Ribble Valley Borough Council
Church Walk,
Clitheroe,
BB7 2RA

Phone: 0300 123 6780
Email: lhscustomerservice@lancashire.gov.uk
Your ref:
Our ref: LHS/CS/3/2015/0649
Date: 1st October 2015

Proposal:	Erection of ten dwellings with creation of new access to Woone Lane
Location:	Land adj 97 Woone Lane Clitheroe BB7 1BJ
Grid Ref:	373961 - 441141

DRAWING	
LOCATION PLAN	
SCALE	DATE
1:2500 @ A3	Mar 2015
DRAWING NUMBER	REVISION
7025/P/001	-

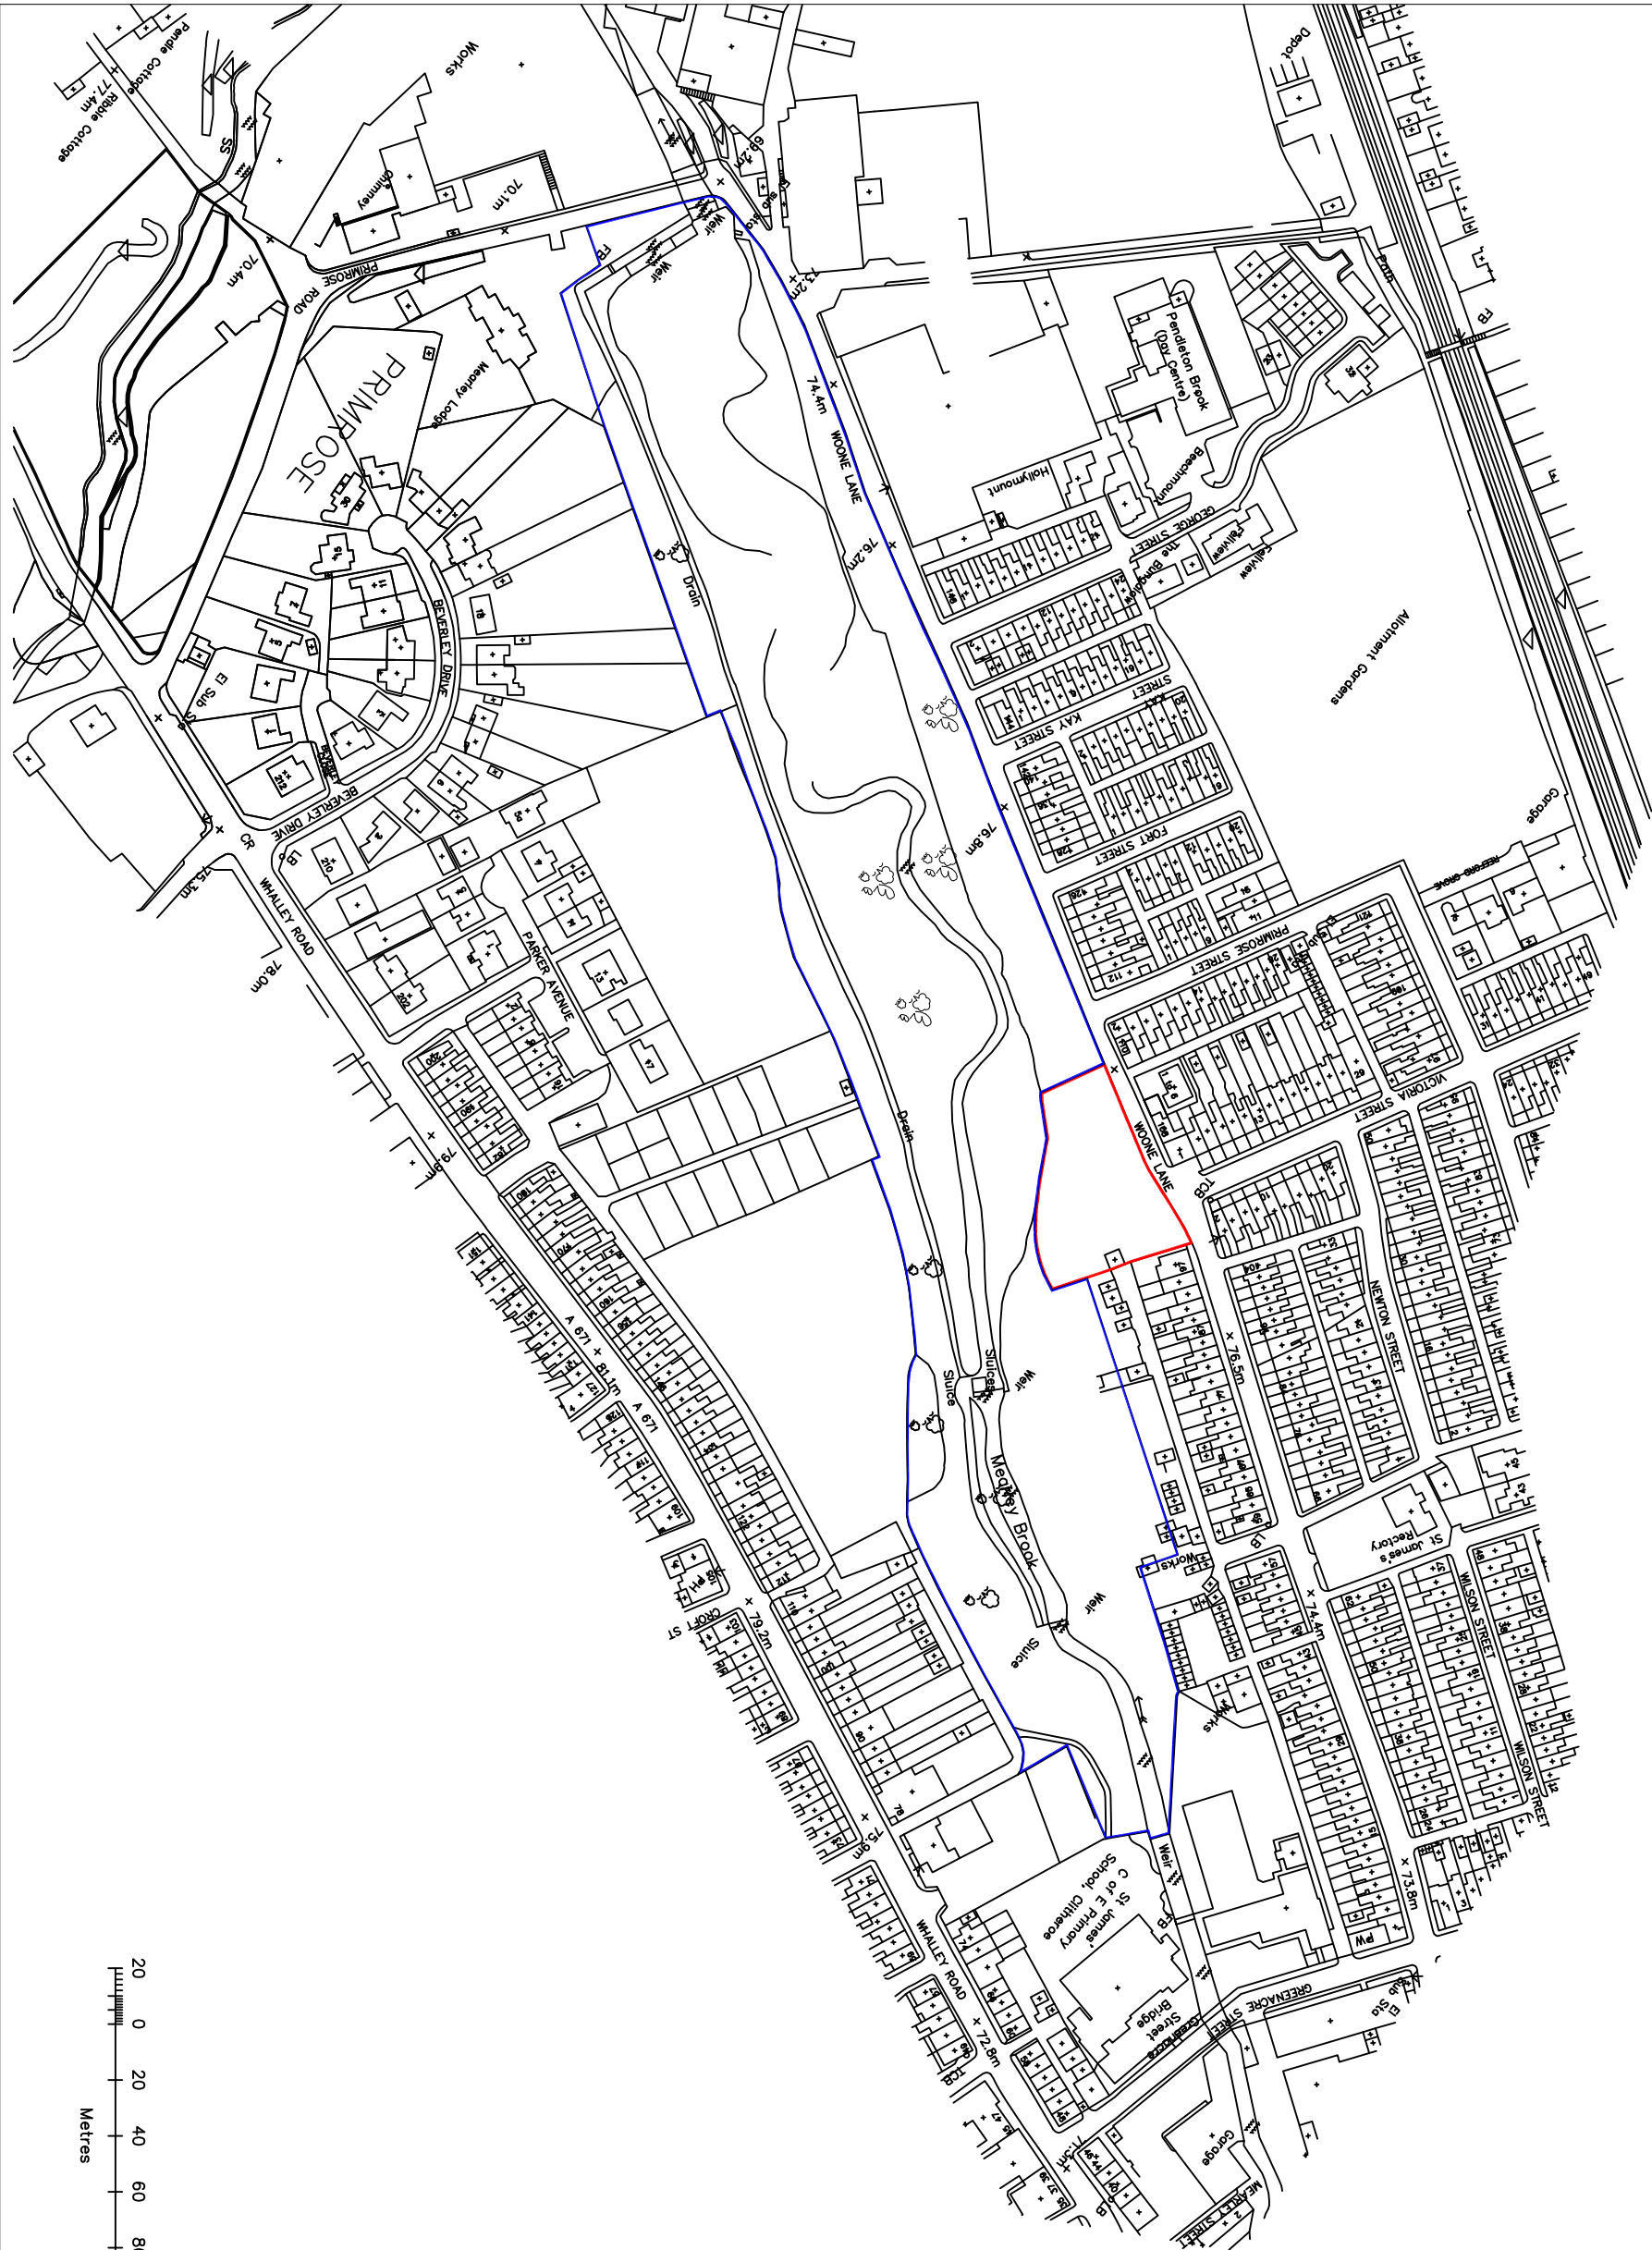
2. The sight lines of 2.4 x 43m to be provided in both directions from the centre of the new site access onto Woone Lane. This requirement was previously shown on the approved drawings for planning application 3/2011/1064

- The applicant should provide accurate details of the required sight line requirement, before determining the application, ensuring the entire sight line requirement is fully over land within the applicants control and/or over the adopted highway and to fully show all works which would be required to provide the sight lines. The sight line splays will require walls, fences, trees, hedges, shrubs, ground growth, structures etc. to have a maximum height of 1.0m above the height at the centre line of the adjacent carriageway.

- From observations on site and the information provided on the applicant's site location plan the sight line requirement is fully achievable over the applicants land providing the stone wall fronting the site is removed.

- The required sight line requirement may be reduced if the applicant can provide an acceptable traffic study, which indicates the 85th percentile traffic speeds are less than 30mph. The traffic study would need to be carried out over a full week by an approved specialist showing the 85th percentile wet

- road traffic speeds in both directions the numbers of vehicles, types of vehicles and the speed of vehicles passing the proposed new access.
3. The applicant to provide a continuous 2m wide footpath for the full frontage of the site to support social inclusion and the promotion of sustainable forms of transport of any further development of the land to the south west of the site. This requirement was previously shown on the approved drawings for planning application 3/2011/1064.
 4. The refuse collection point is to be off the adoptable footpath to reduce the impact of pedestrians passing the site, in the future and the obstruction of the sight lines from the new site access. The refuse collection point should also be relocated as a resident should not be required to carry the waste more than 30m to the refuse storage point. From Manual for streets and BS5930: 2005.
